The Parish Councils of Assington, Bures St Mary, Leavenheath, Little Cornard, Polstead & Stoke by Nayland

Strategic Options, TS Conductor & Impact of Proposed Bramford to Twinstead Reinforcement Works

Response to Applicant's Submissions at Deadlines 8 & 9

DEDHAM VALE EAST SEALING END COMPOUND:
 PLAN VIEW
 SCALE 1:200

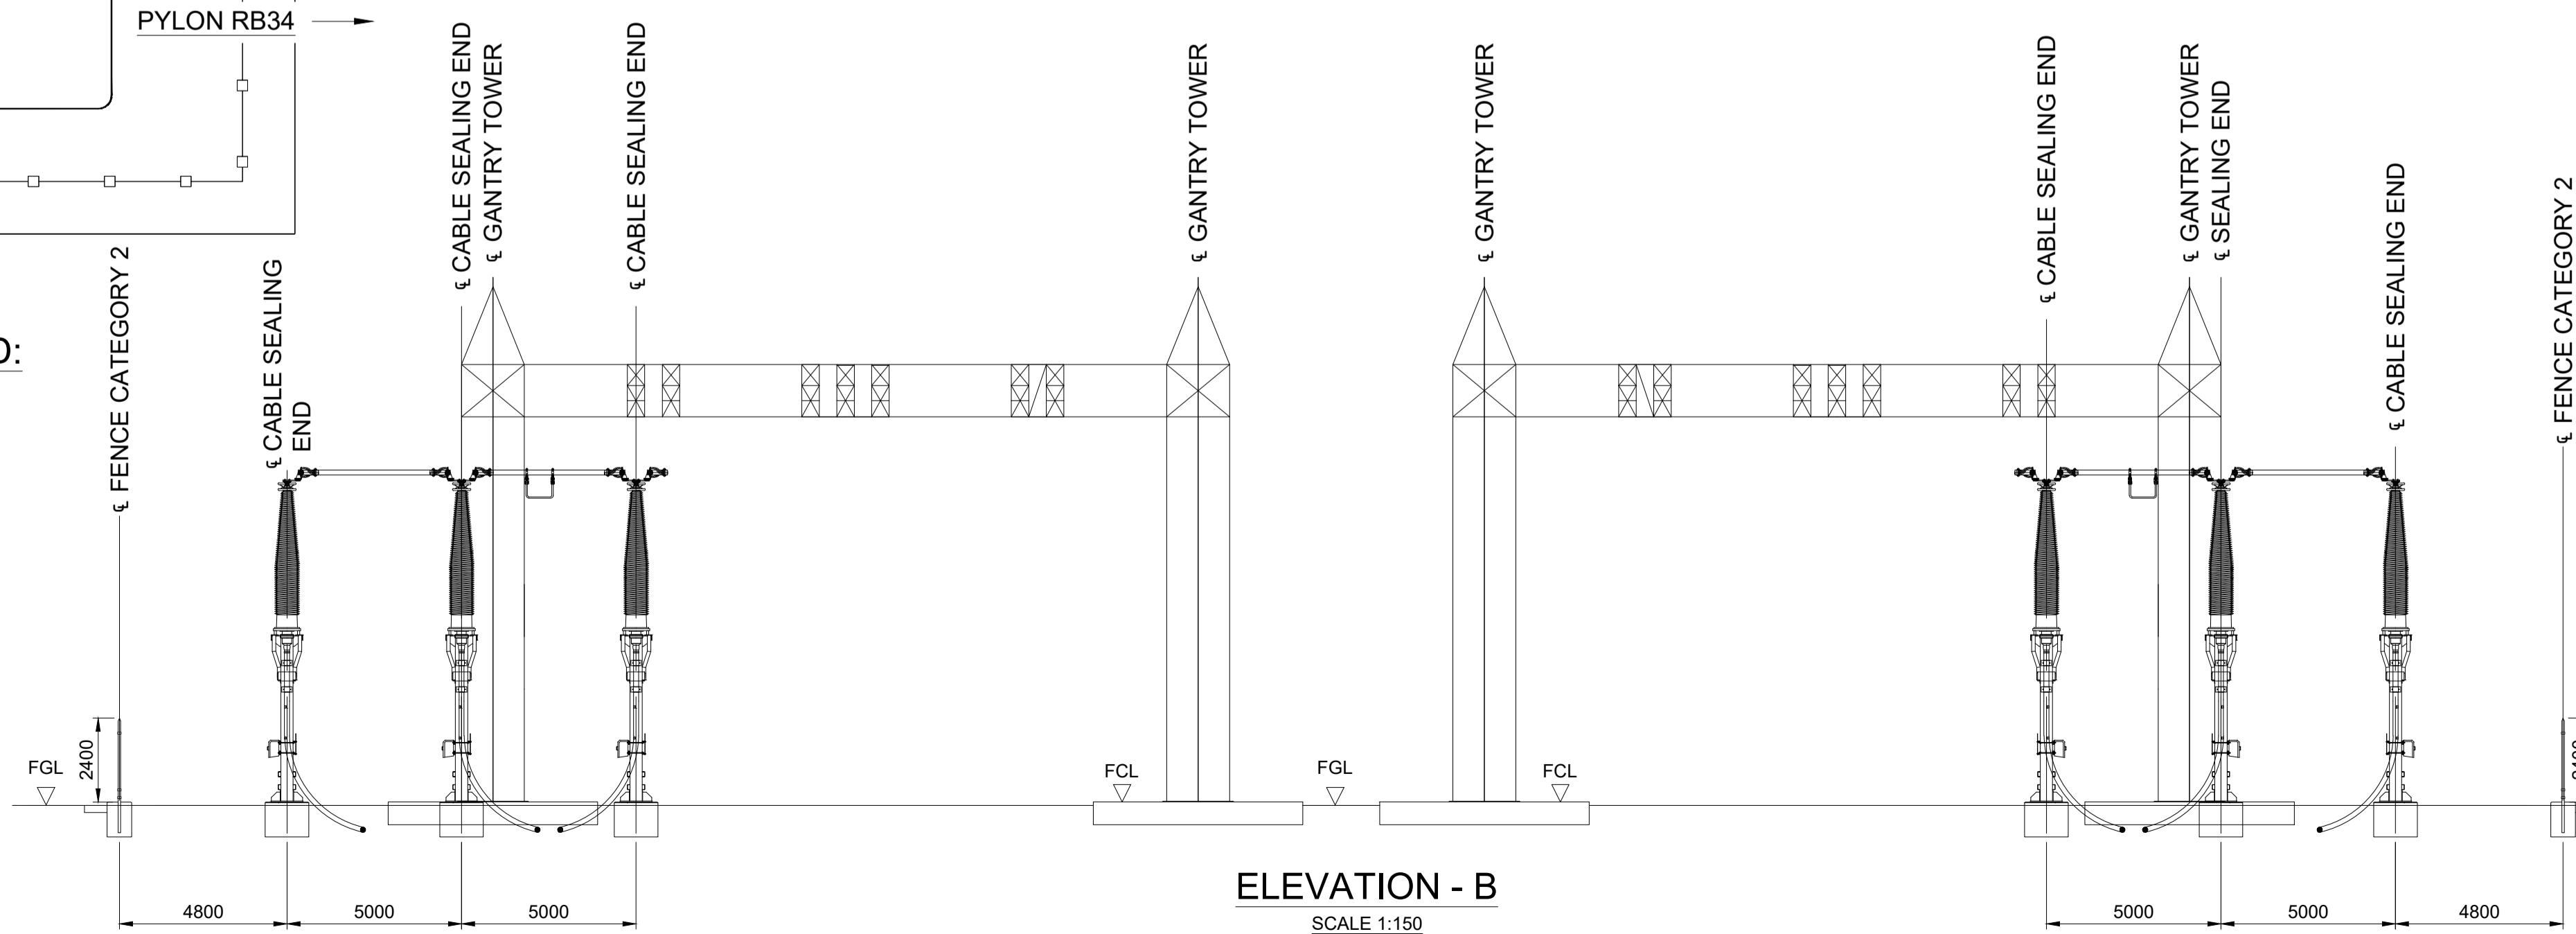
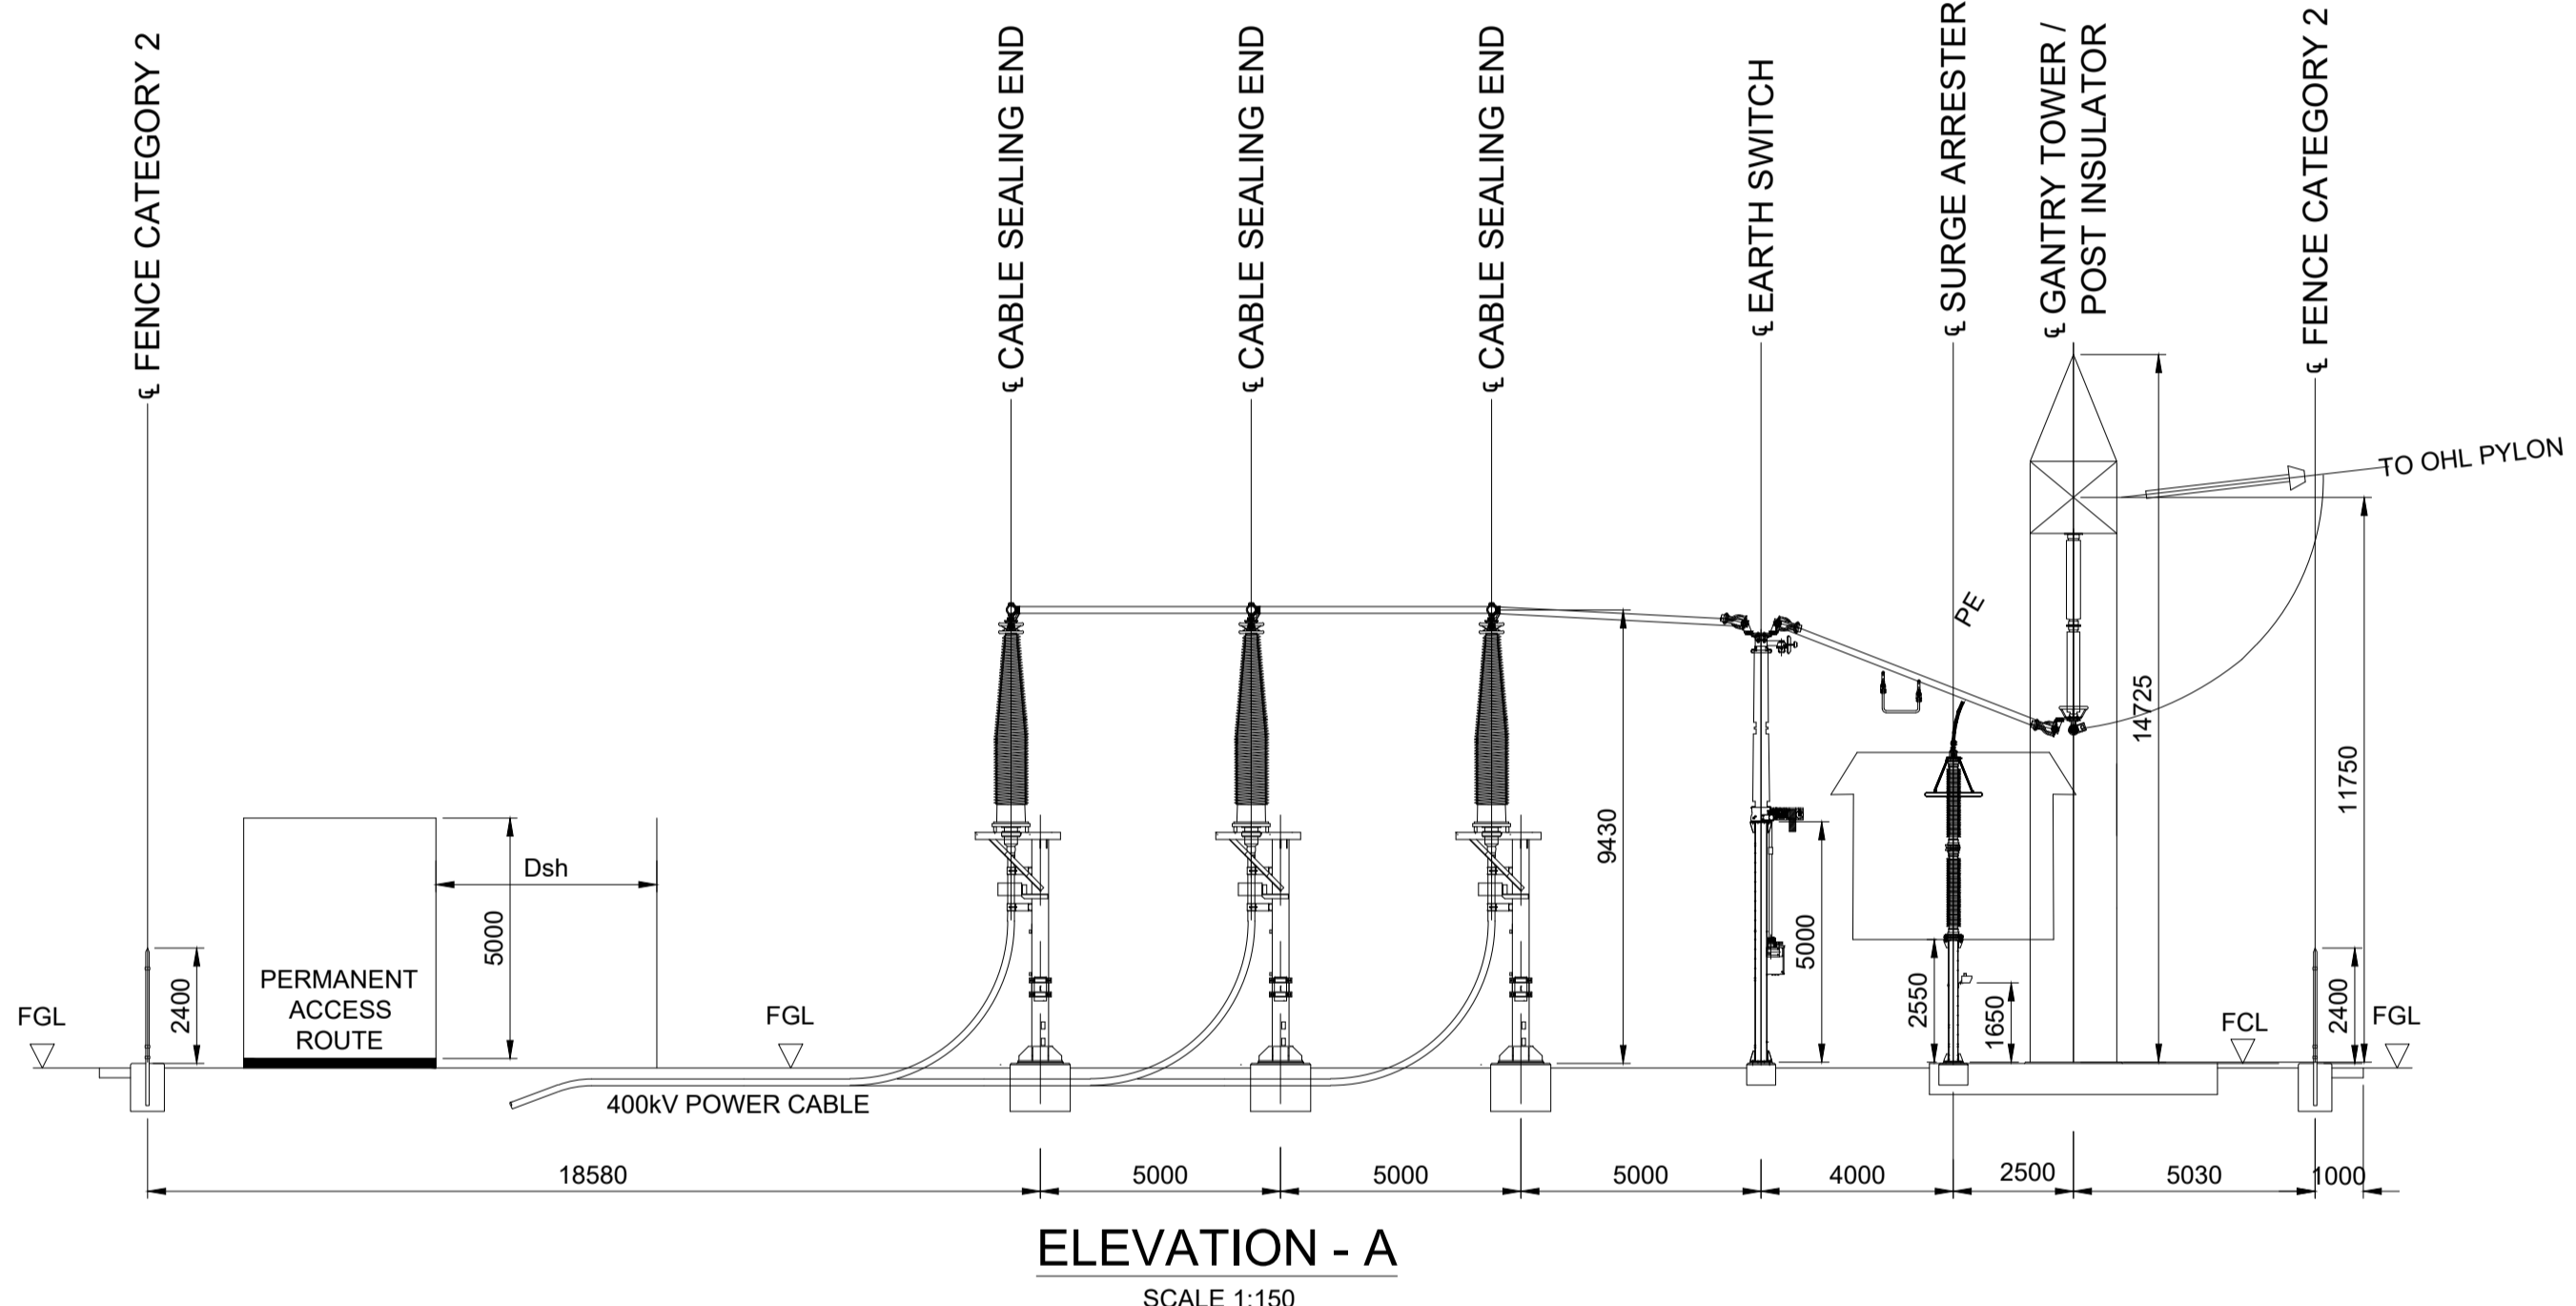
3.2 We completely reject the assertion from the Applicant that *“its proposed site for the Dedham Vale East CSE compound is the most suitable location taking into account all of the relevant factors”*. We are especially concerned over (i) the ranking of the visual impact of the CSE gantries, switchgear and compound below that of the existing 275kV power line that they replace at the Millfield Woods site, and (ii) the assertion that the planting proposals, essentially hedgerow reinforcement, will ameliorate the impacts over time. The communities that we represent consider these arguments on which the Applicant relies to be especially confounding.

3.3 Our aim throughout has been to demonstrate to the ExA the superiority of the quarry alternative on a wide range of practical and environmental grounds. We place our trust in the ExA agreeing that the additional costs associated with the additional undergrounding are more than offset by the benefits secured, and to recommend to the SoS that the compound be relocated into the quarry.
